Our ref: HA/2020/122070/02-L01
Your ref: LU/48/20/PL
Date: 09 April 2020

APPLICANT'S ENGINEER'S RESPONSE - DEMOLITION OF 1 NO. BUNGALOW & OUTBUILDINGS & ERECTION OF 22 NO. DWELLINGS WITH ASSOCIATED PARKING & OPEN SPACE. THIS APPLICATION IS A DEPARTURE FROM THE DEVELOPMENT PLAN.

SOUTHDOWN NURSERY OLD MEAD ROAD LITTLEHAMPTON BN17 7PU

SCALE	DATE	DRAWN BY
1:200	December 2019	ANH
DRAWING NO.	REVISION	
2019/124/PL02	-

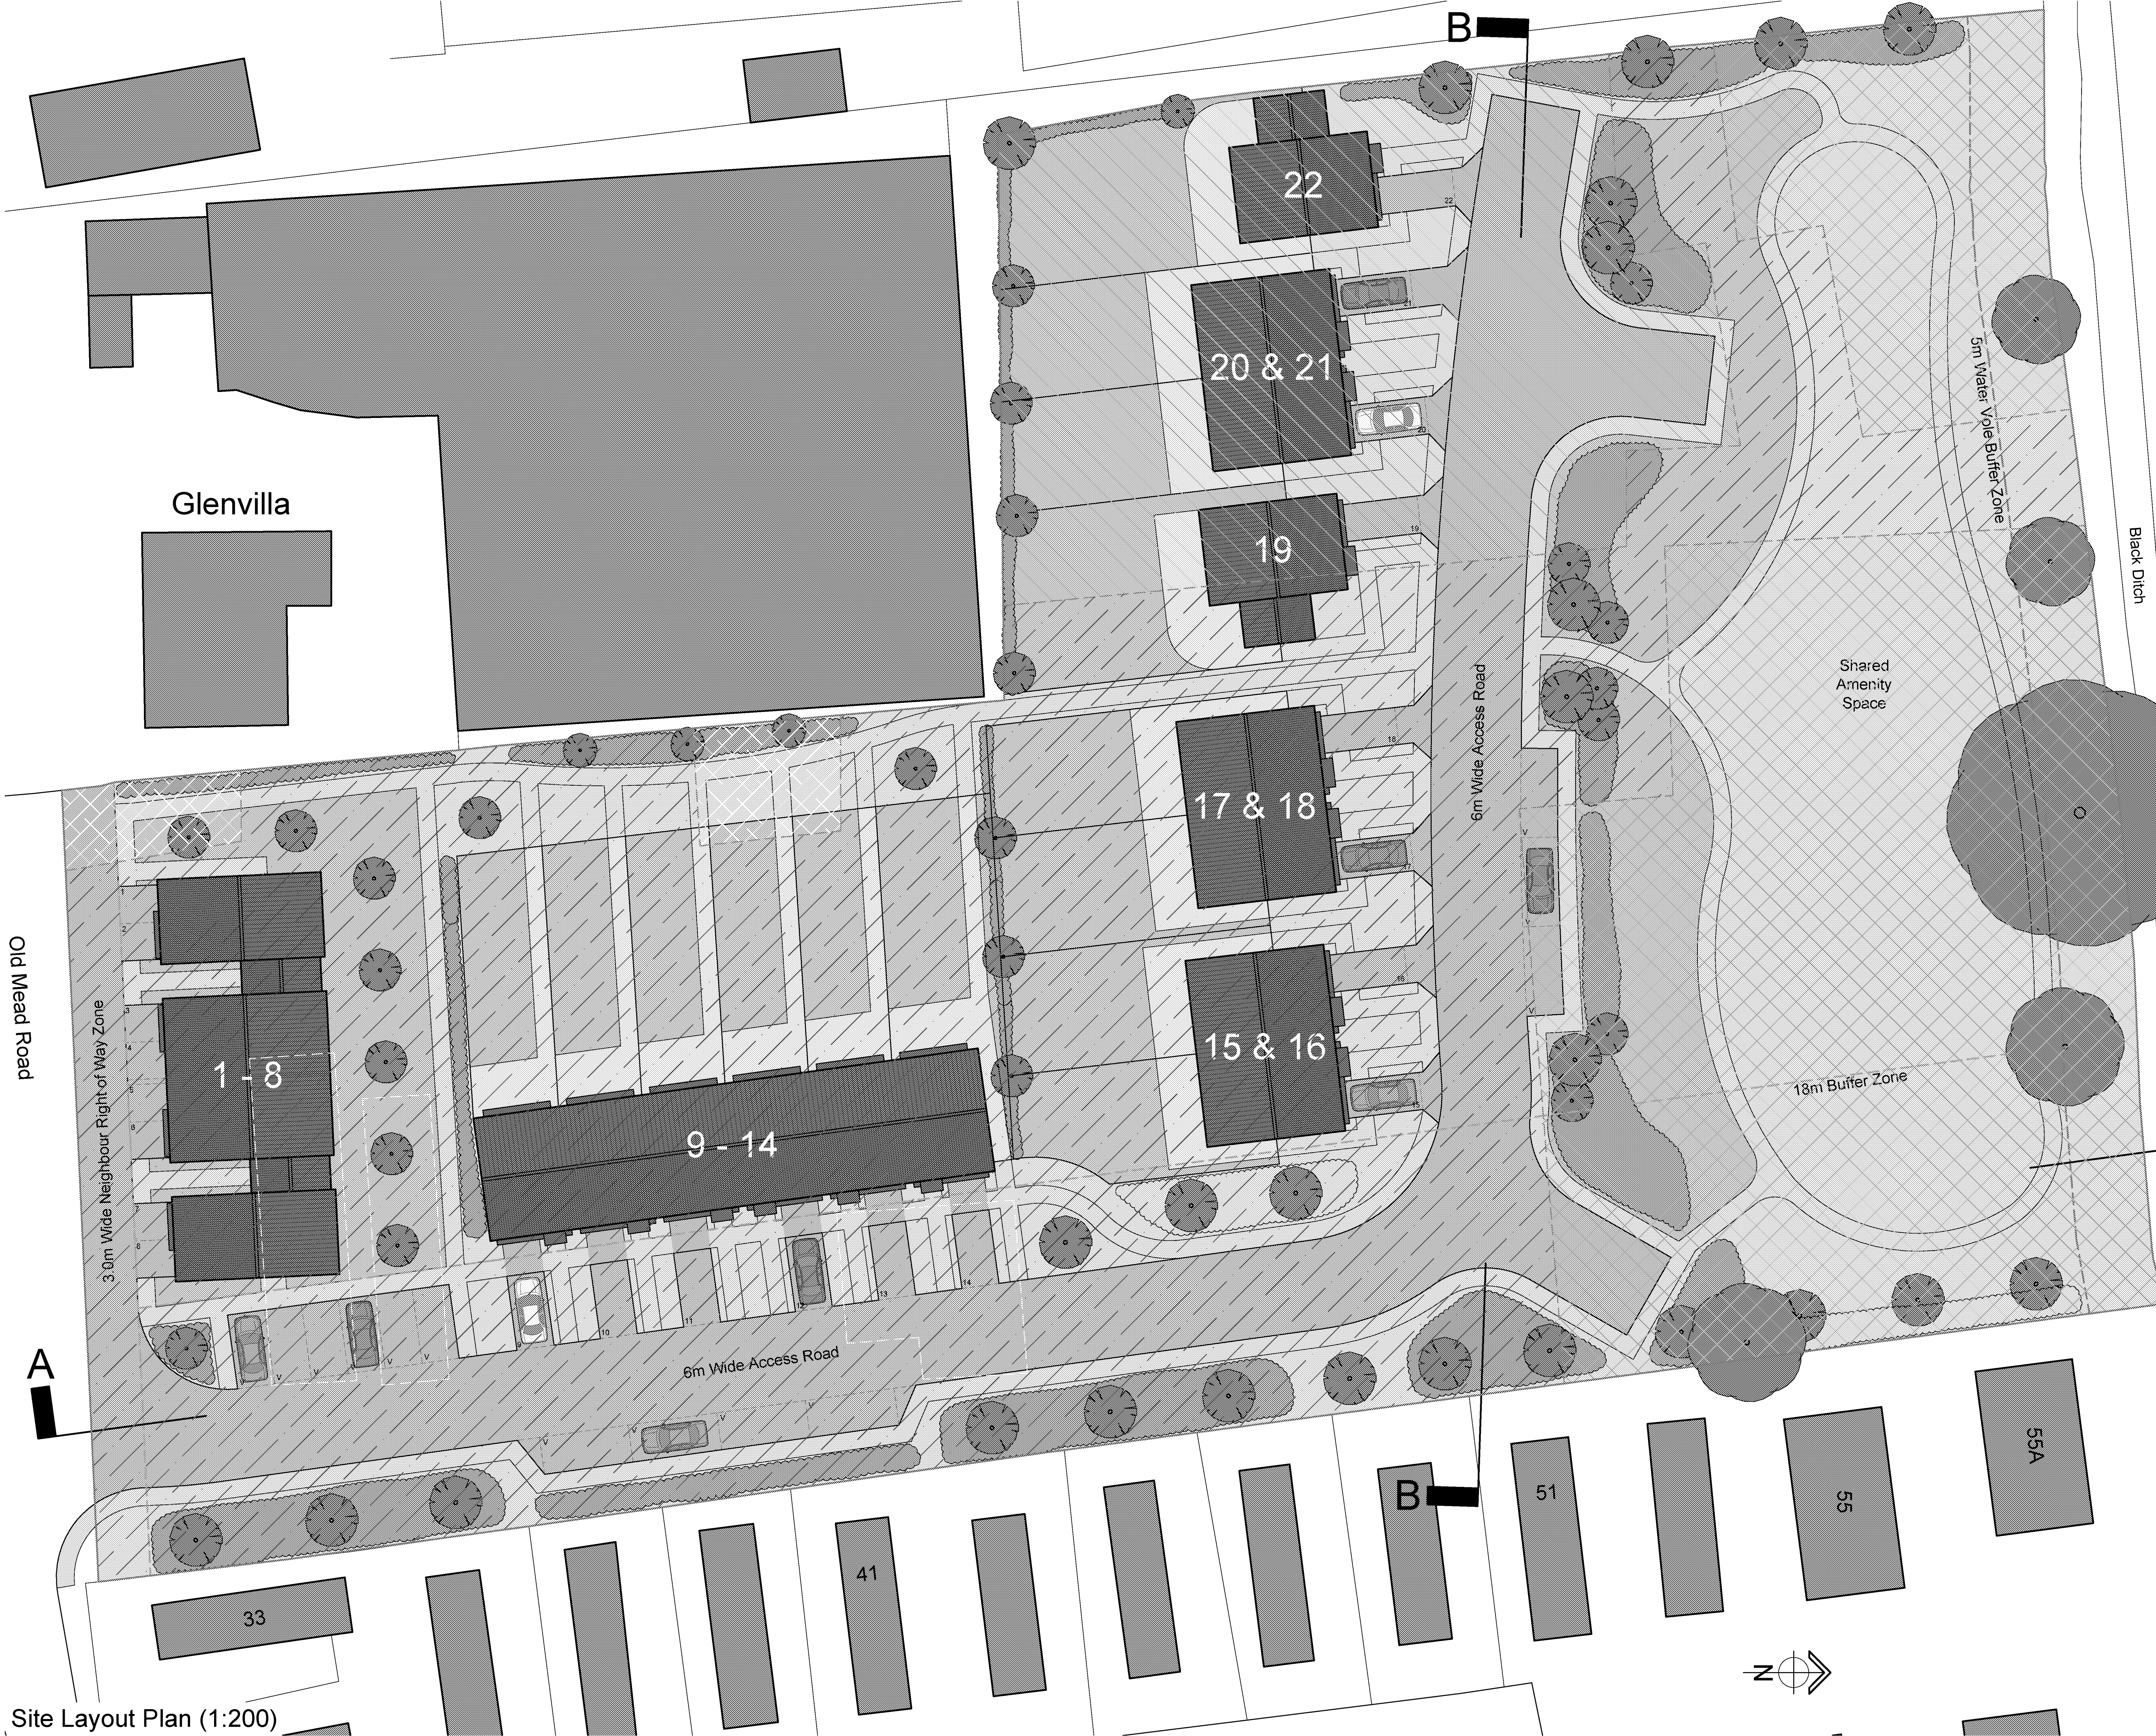
The EA would reiterate that the FRA detail is insufficient, and that it needs to demonstrate in more detail, that in particular the flood plain compensation is feasible. It would be unreasonable for the EA at this stage, to recommend the implementation of a planning condition, if it is later found to be unachievable. Therefore the information provided is not sufficient to determine in principle if the flood plain compensation is adequate.

Furthermore an additional 7.45m³ of flood storage based on a desk study, does not allow a lot of margin for error, particularly as at some point there will be a strong likelihood of encountering groundwater.

If Monson can identify the area that needs to be lowered showing how they have calculated the loss of flood storage and that it is feasible to lower the ground levels to ensure adequate flood plain compensation is provided up to the climate change levels (45% and 105% increase in flow), then we can potentially condition this element of the application, and review our objection. At this stage we do not have enough information

On a final point, whilst surface water run off and the design of SUDS systems are not commented upon by the EA, we would not support SUDS features (i.e attenuation basin and attenuation tanks, etc.) located within the flood plain, and we would re-iterate our concerns in regards to the site ability to discharge to the Black Ditch, particularly during periods of prolonged rainfall, when the Black Ditch can be effectively tide locked for long periods due to inundation within the River Arun valley flood plain.
